Subject: Retreat at TimberRidge Filing No. 1 Final Plat, Review #2 (SF-19-009)

The Planning Division of the Community Services Department has reviewed the Retreat at TimberRidge Filing No. 1 Final Plat, Review #2, and has the following additional comments of behalf of El Paso County Parks. Staff recognizes the addition of General Plat Note #21, which states, ***“Tract A is for regional and local trail, existing drainageway, public utilities, and open space. Tract will be owned and maintained by El Paso County, upon completion of the required improvements and county acceptance. Retreat at TimberRidge Homeowners Association shall be responsible for the aesthetic maintenance.”*** Until such time that Tract A is accepted by and deeded to El Paso County, the dedication to El Paso County of a 25’ trail easement will continue to be required along this section of Sand Creek, and furthermore, other forthcoming final plats within the Retreat at TimberRidge may require trail easement dedication as well, until such time that tract ownership is offered to and accepted by El Paso County.

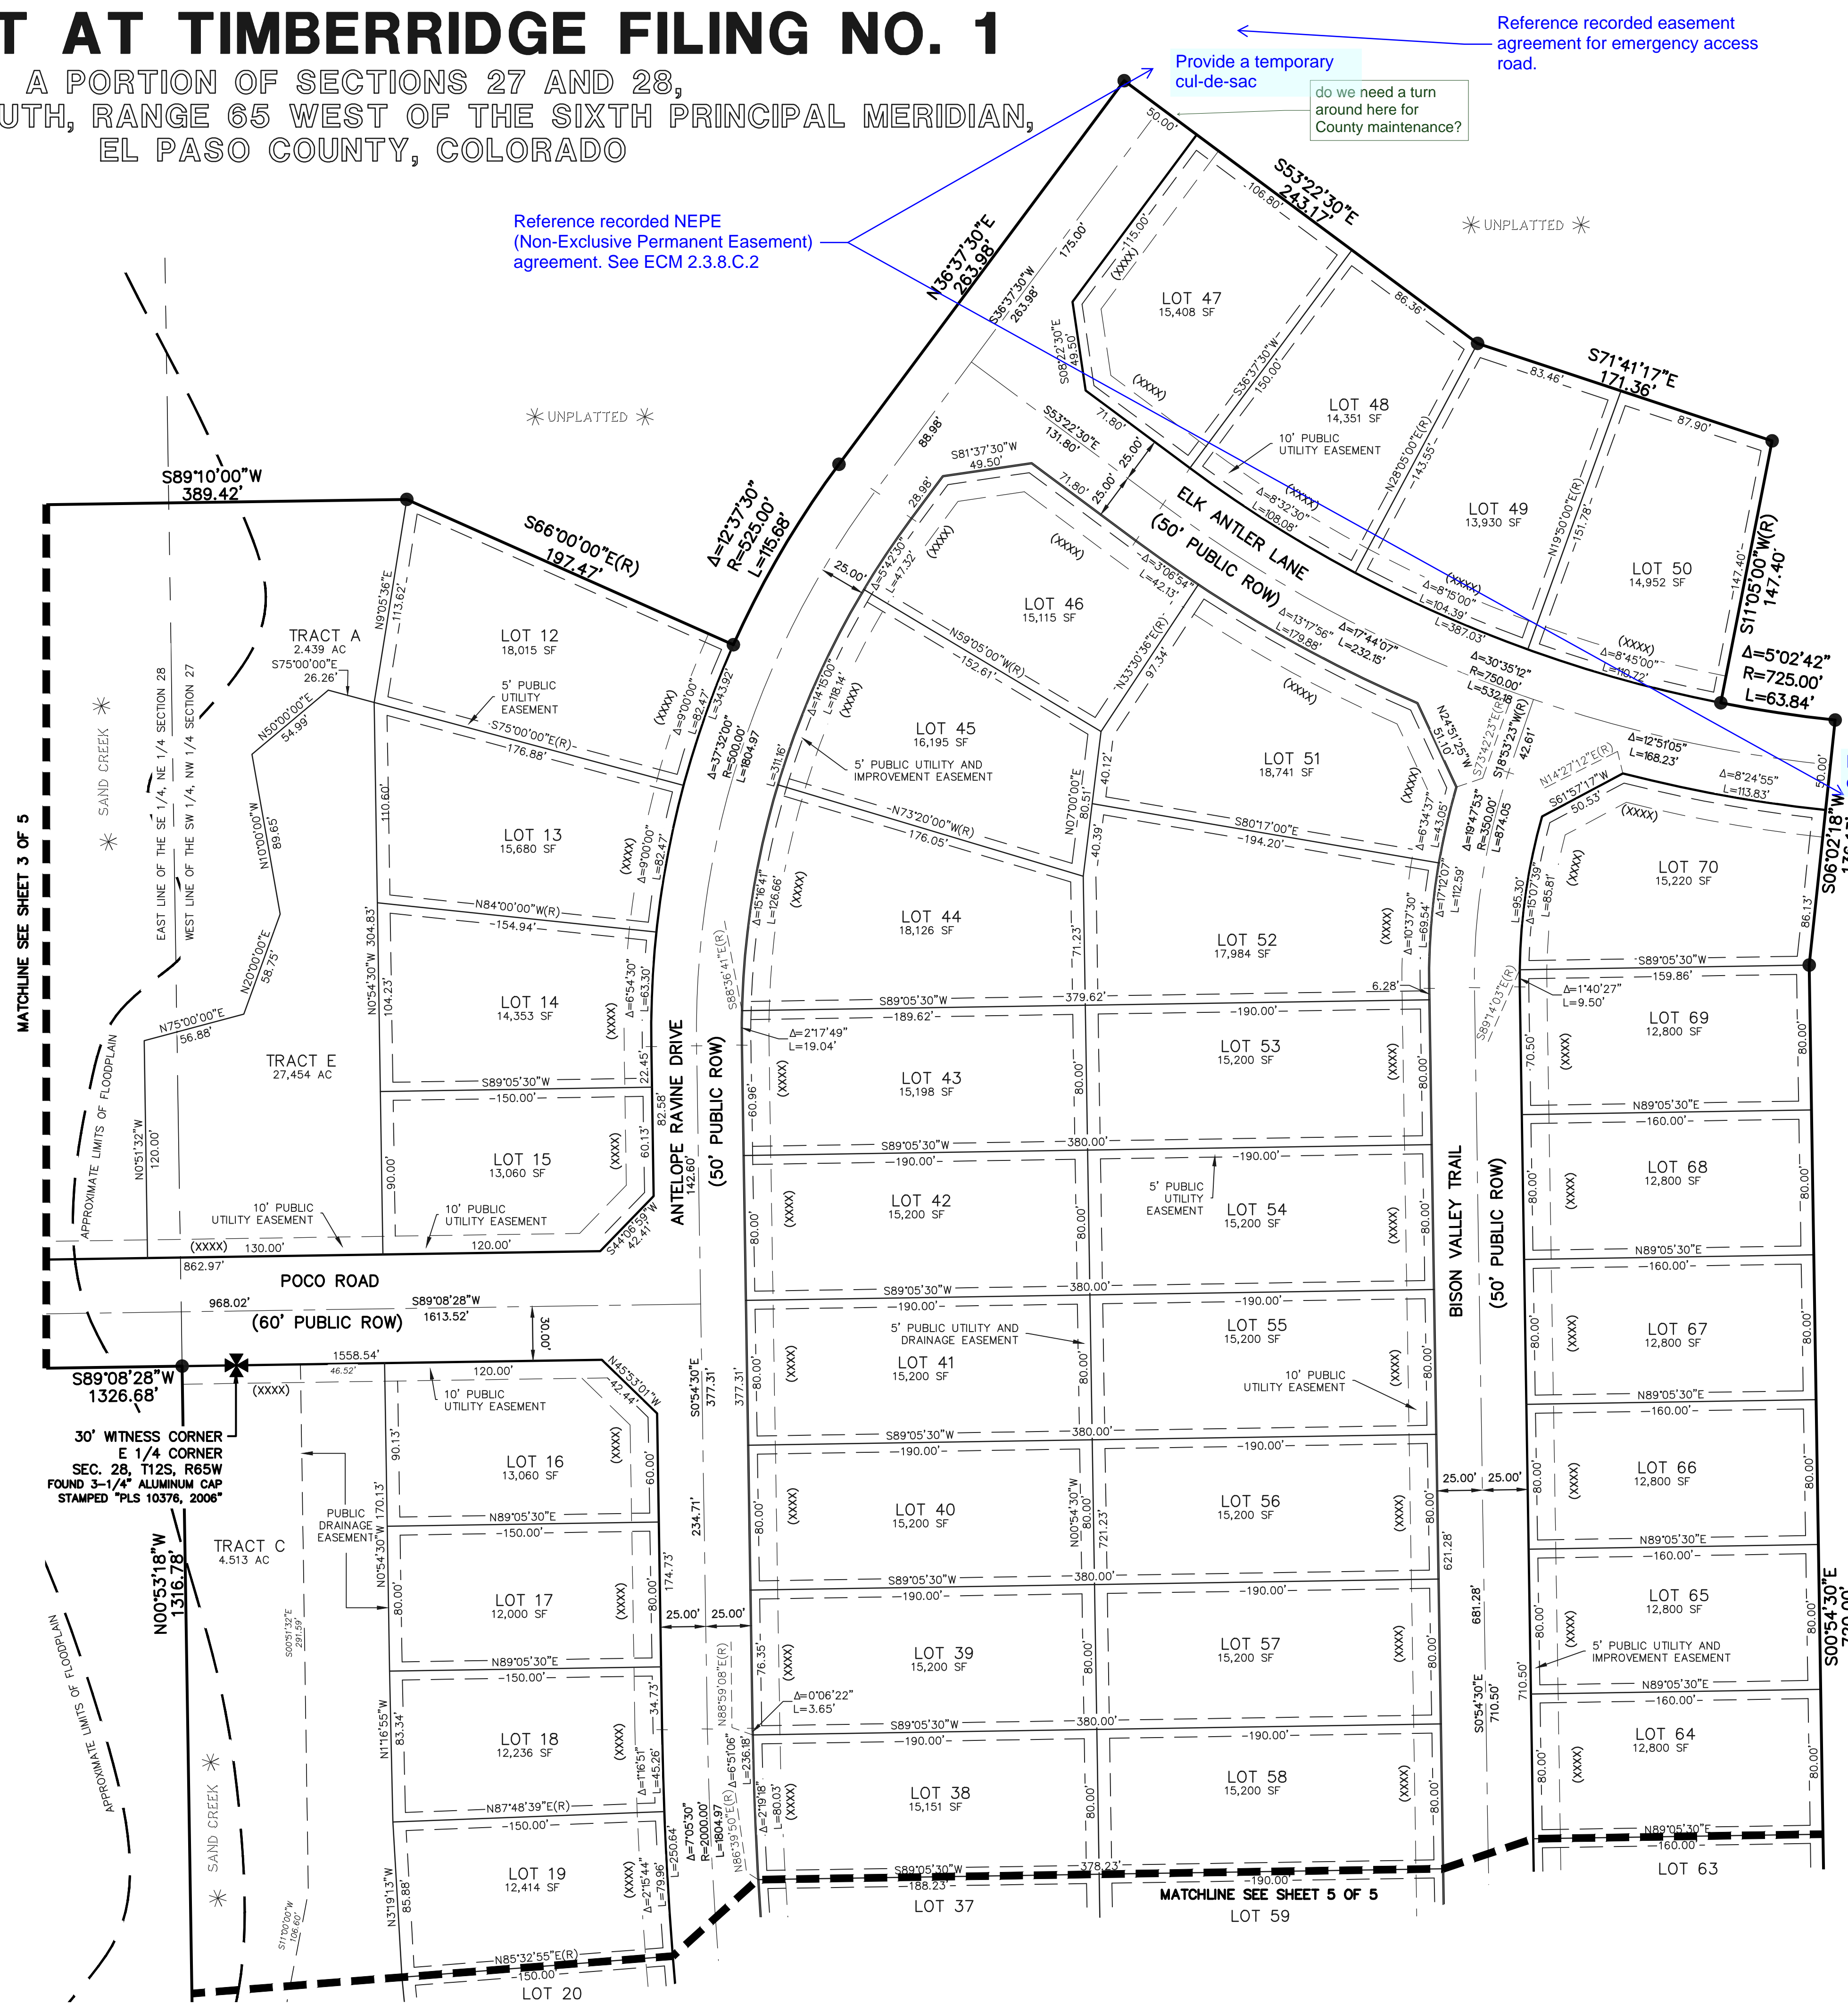
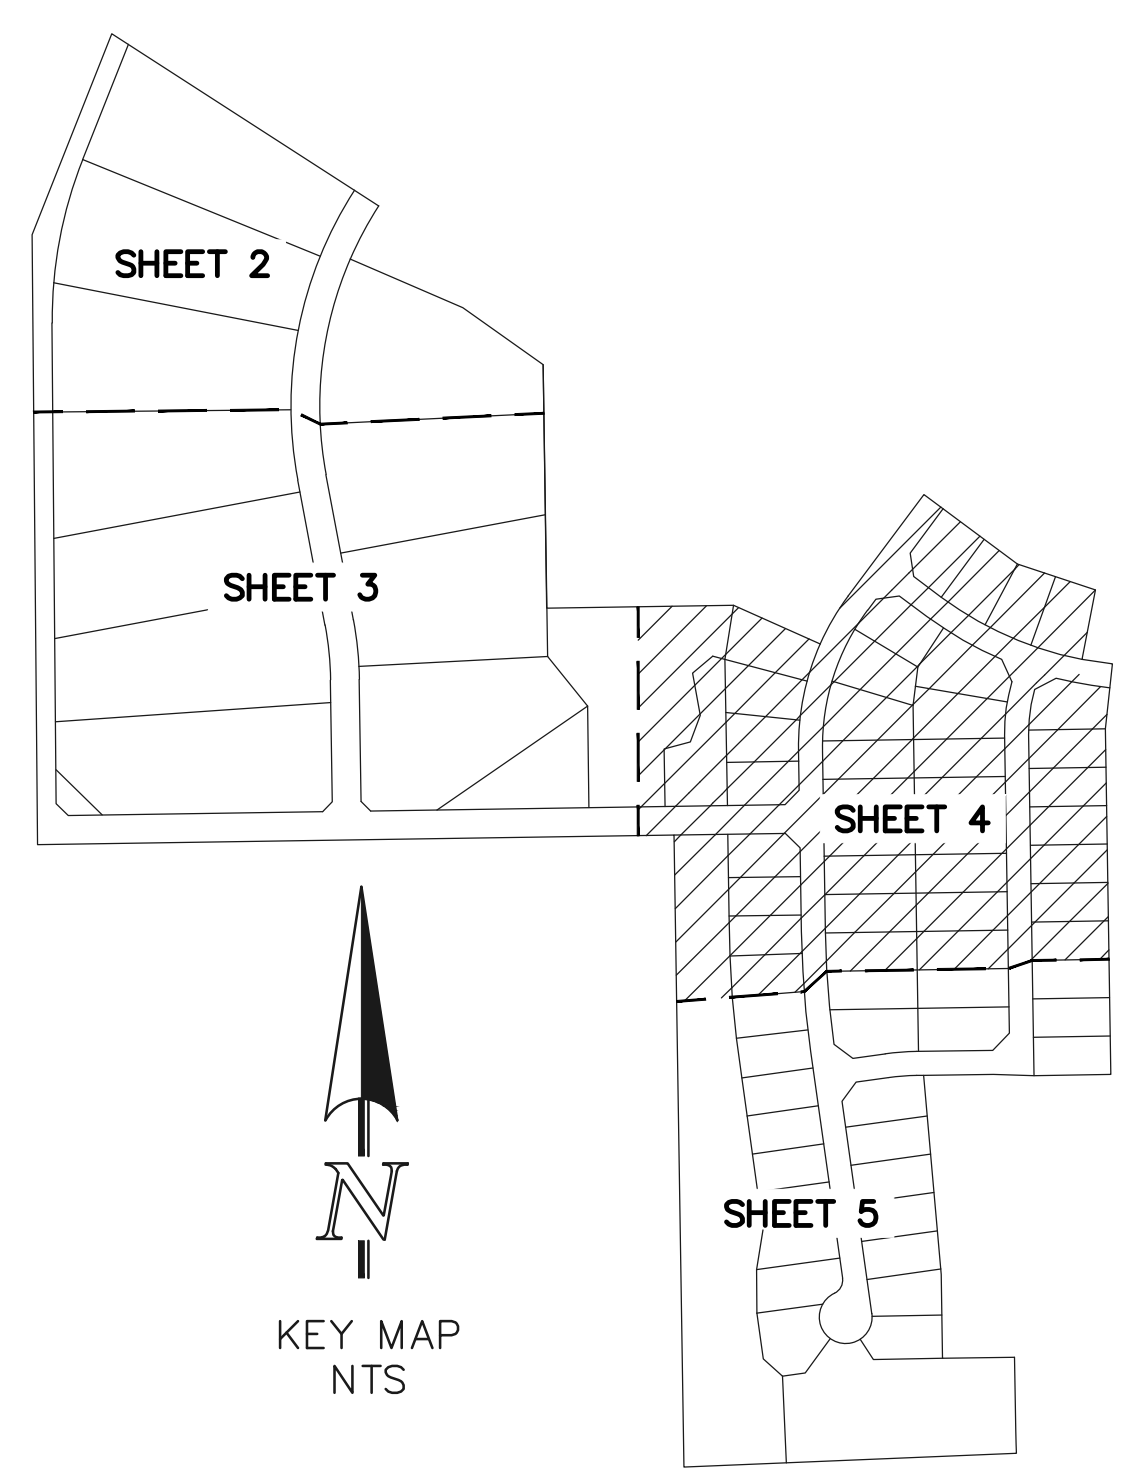
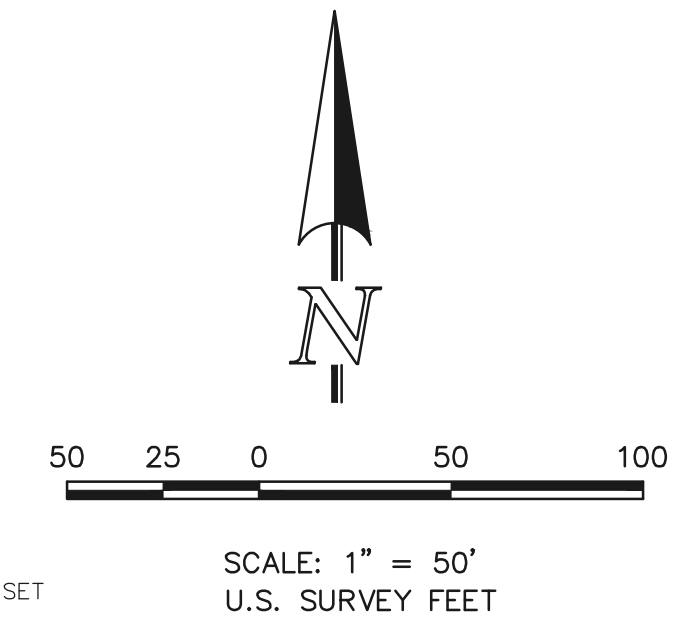
The current Filing No. 1 Final Plat application includes 0.63-acre Tract E, which according to General Note #25, is designated for “public park and open space,” to be owned and maintained by the TimberRidge Metropolitan District. While much smaller than the originally-planned 3.6-acre neighborhood park, this park facility will allow for additional recreation facilities for the residents of the Retreat at TimberRidge. Moreover, the applicant states in their Letter of Intent, that “an El Paso County regional multi-use trail (10’ wide gravel) will be provided along the west side of Sand Creek and the south side of Arroya Lane within a 25’ trail easement.” This trail easement, however, is not shown on the current Final Plat.

In addition to regional and urban park fees, Parks staff requires that the applicant provide to El Paso County a 25-foot public trail easement along the Sand Creek drainage that allows for public access, as well as construction and maintenance by El Paso County of the regional trail, and this easement be shown on and dedicated to El Paso County on this Final Plat. A park lands agreement may be acceptable alternative to urban park fees, should the applicant choose to build the neighborhood park to a cost that meets or exceeds the urban park fees for Filing No. 1.

Recommend to the Planning Commission and Board of County Commissioners that approval of the Retreat at TimberRidge Filing No. 1 Final Plat include the following conditions: (1) provide to El Paso County a 25-foot public trail easement along the Sand Creek drainage that allows for public access, as well as construction and maintenance by El Paso County of the Sand Creek Primary Regional Trail, and this easement shall be shown on and dedicated to El Paso County on this Final Plat; (2) require fees in lieu of land dedication for regional park purposes in the amount of \$31,920 and urban park fees in the amount of \$20,160. A park lands agreement may be an acceptable alternative to urban park fees, provided the agreement is approved by the County and executed prior to recording this Final Plat.”
